WEST SUSSEX COUNTY COUNCIL CONSULTATION

TO:	Arun District Council - FAO: Simon Davis
FROM:	WSCC - Highways Authority
DATE:	20 August 2021
LOCATION:	Land North of 1 Northfields Cottages, Fontwell Avenue, Eastergate, PO20 3RX
SUBJECT:	BN/98/21/DOC Approval of details reserved by condition imposed under BN/50/20/PL relating to conditions 5, 7, 8, 10, 11, 13, 17, 18 & 20
RECOMMENDATION:	No Objection

Condition 8 - Construction & Environmental Management Plan (CEMP)

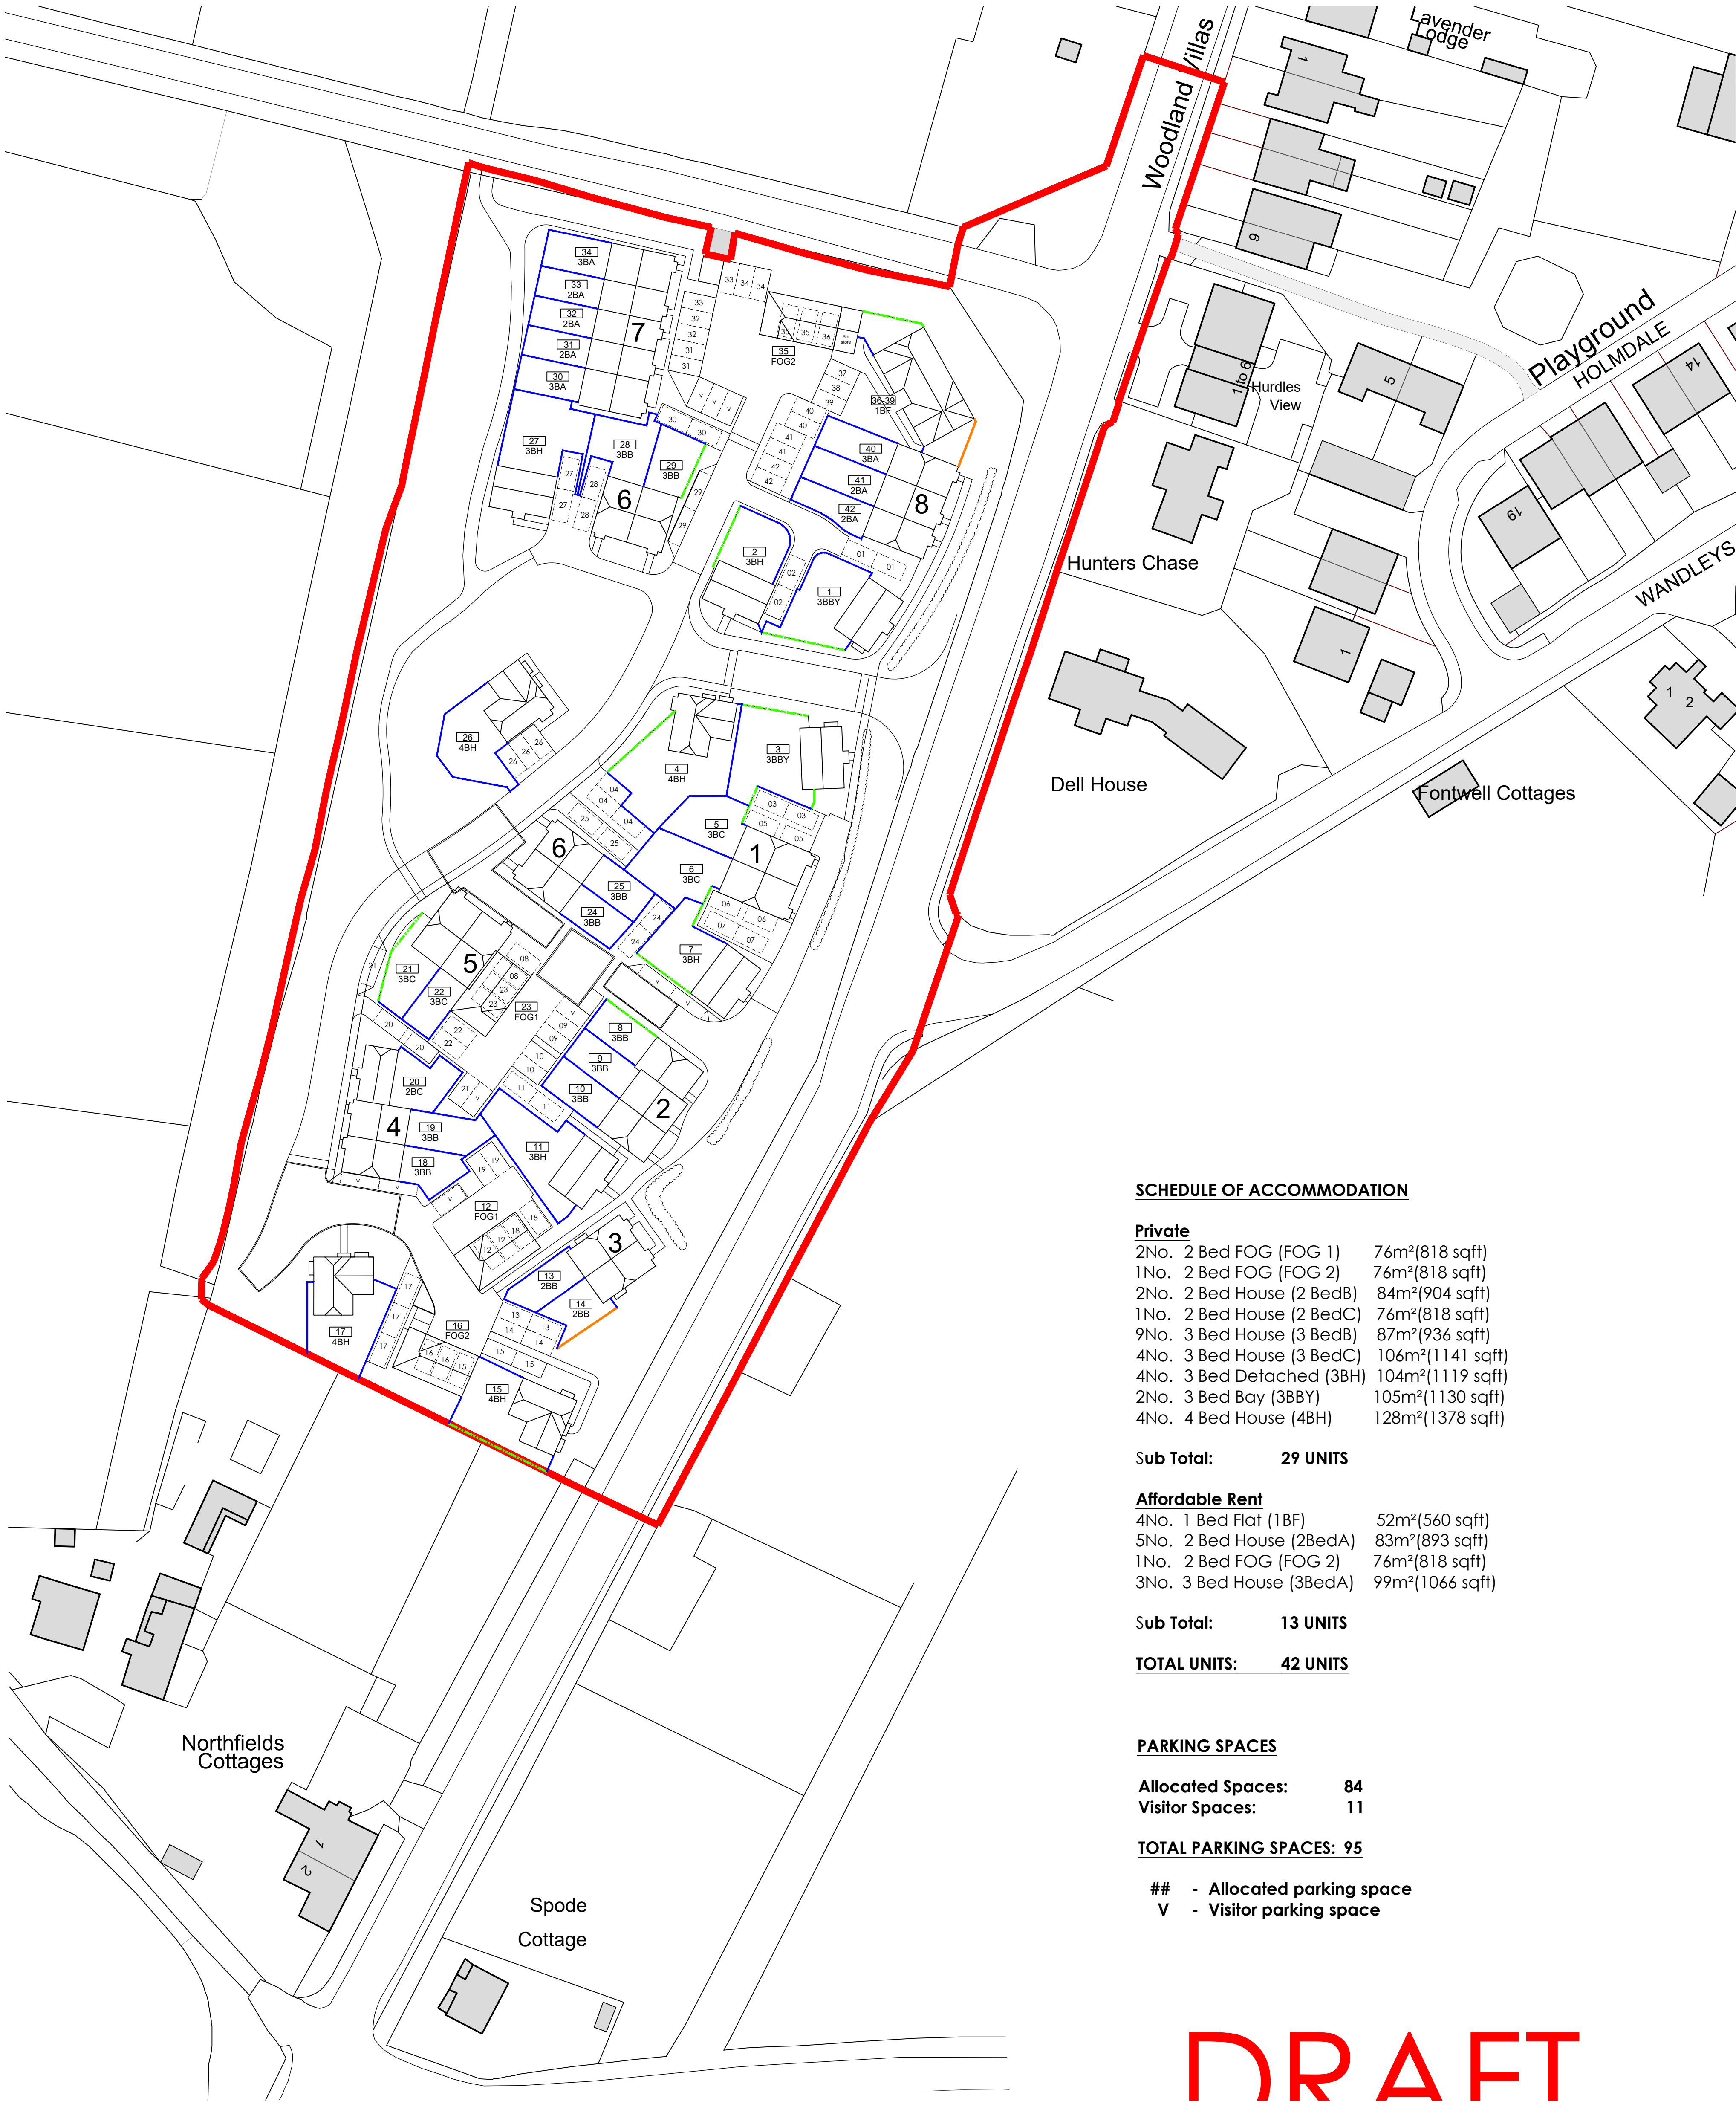
unclear from the plan whether the closeboard fence is close to the road, advise set back so visibility for construction vehicles not impacted.
